From: Paul Cann
Sent: 02 March 2018 10:55
To: 'Alistair'
Cc: Phil Wiltshire; Gavin Mustion; Simon Davis; Lisa Clarke; Engineering
Subject: RE: 17-1779 Re Y/52/17/DOC Longacre, Maypole Lane

From: Alistair [REDACTED]
Sent: 01 March 2018 16:23
To: Paul Cann
Cc: Phil Wiltshire; Gavin Mustion; Simon Davis; Lisa Clarke; Engineering
Subject: 17-1779 Re Y/52/17/DOC Longacre, Maypole Lane

Lavender Cottage Drainage Plan

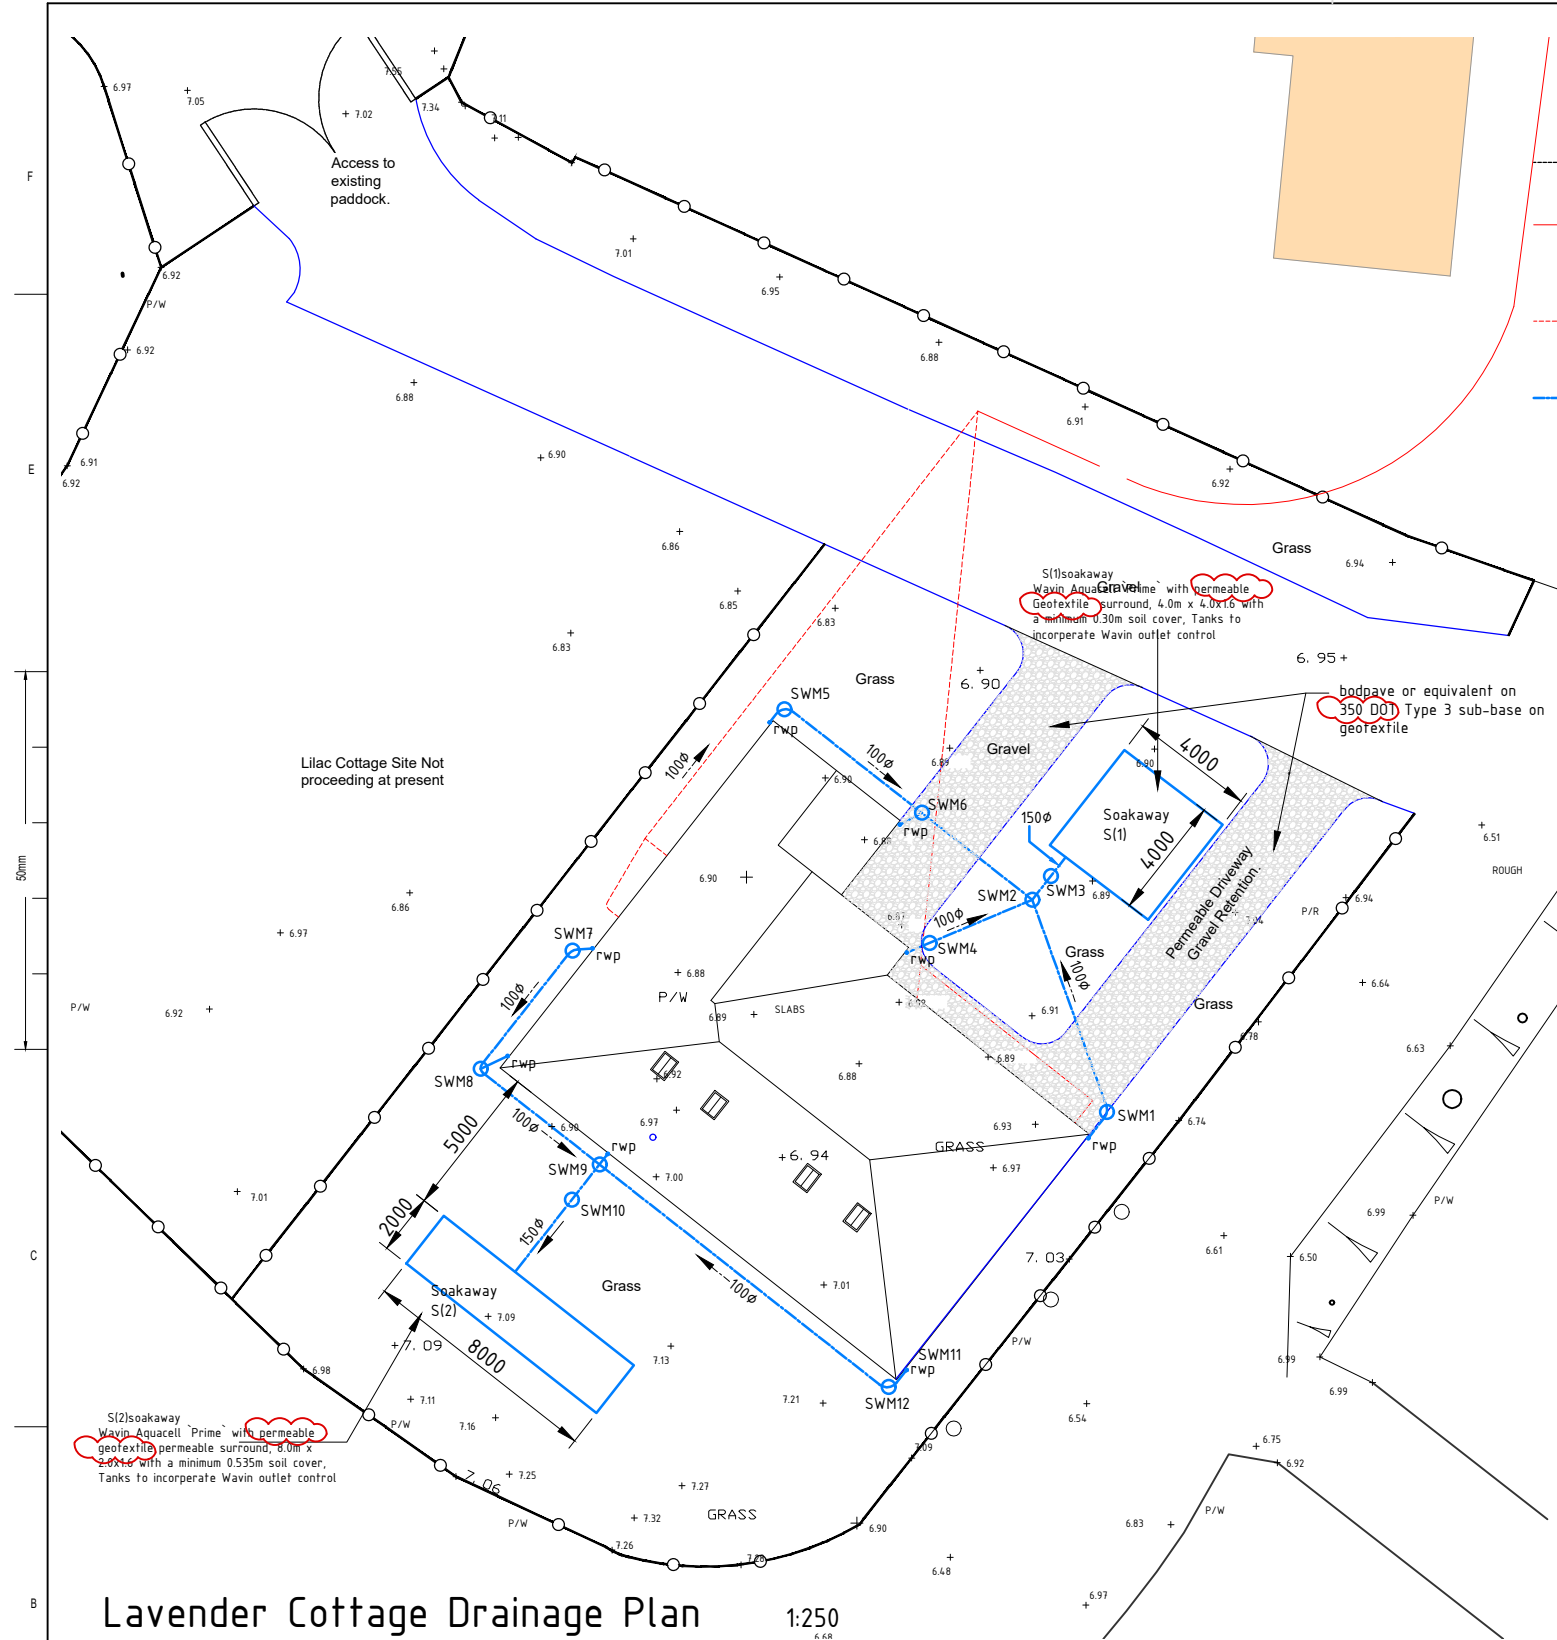
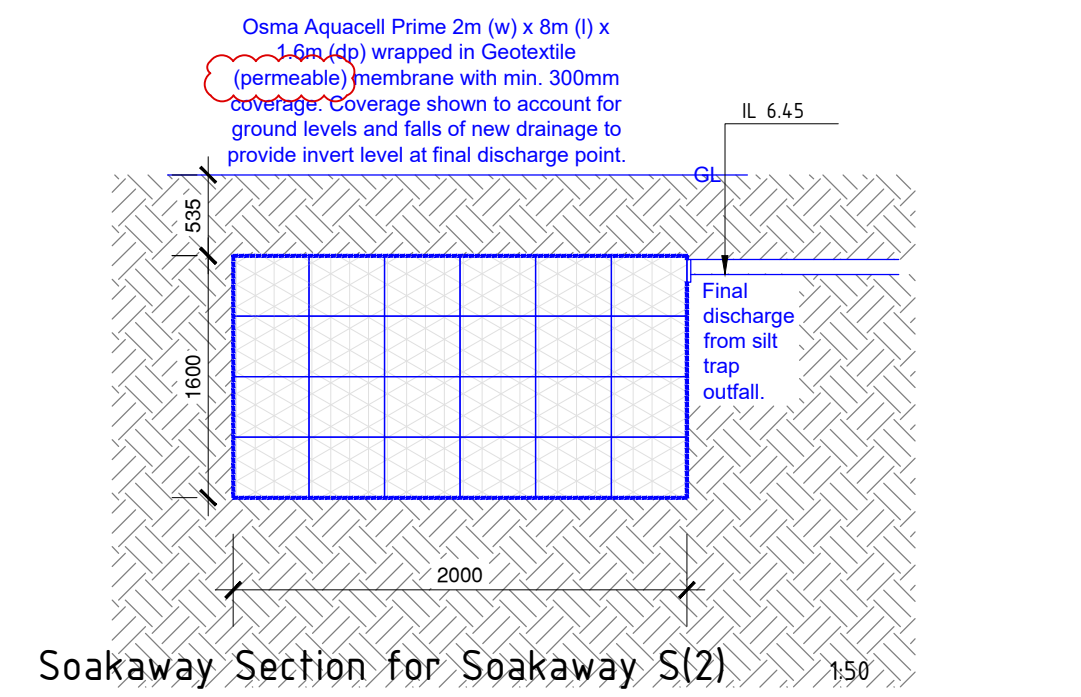
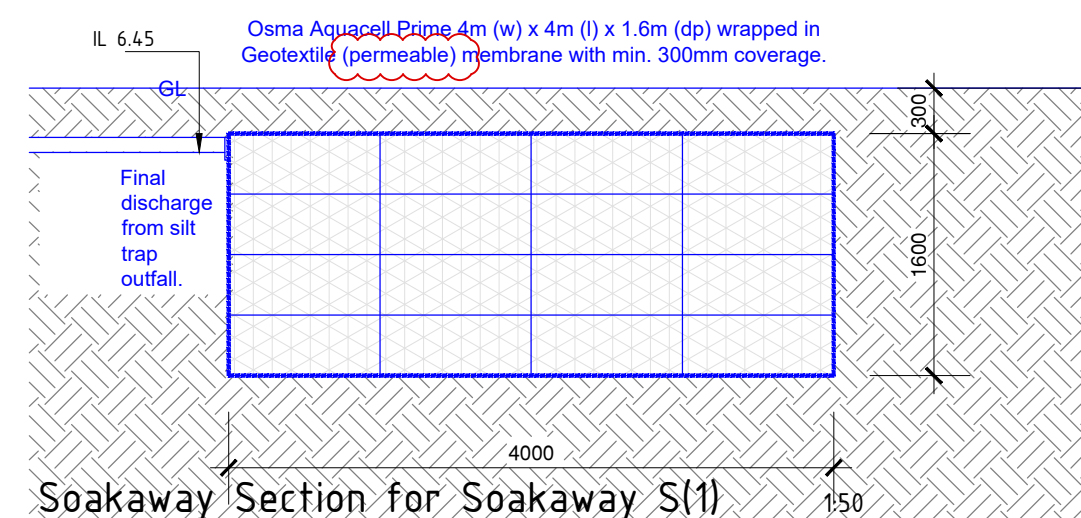
1. The geotextile membrane has been annotated to be permeable. See amended drawing 17-1779/01B appended.
2. Permeable Paving Construction detail. See Philips updated drawings (sent separately)
3. Finished levels. See Philips updated drawings (sent separately) .It has been specified that there should be a minimum 350 thick Type 3 stone.
4. Amended calculations for driveway appended using 30% void ratio as requested. The 95% void ratio stated only refers to the Aquacell system, their data states the void ratio available to be 95%.
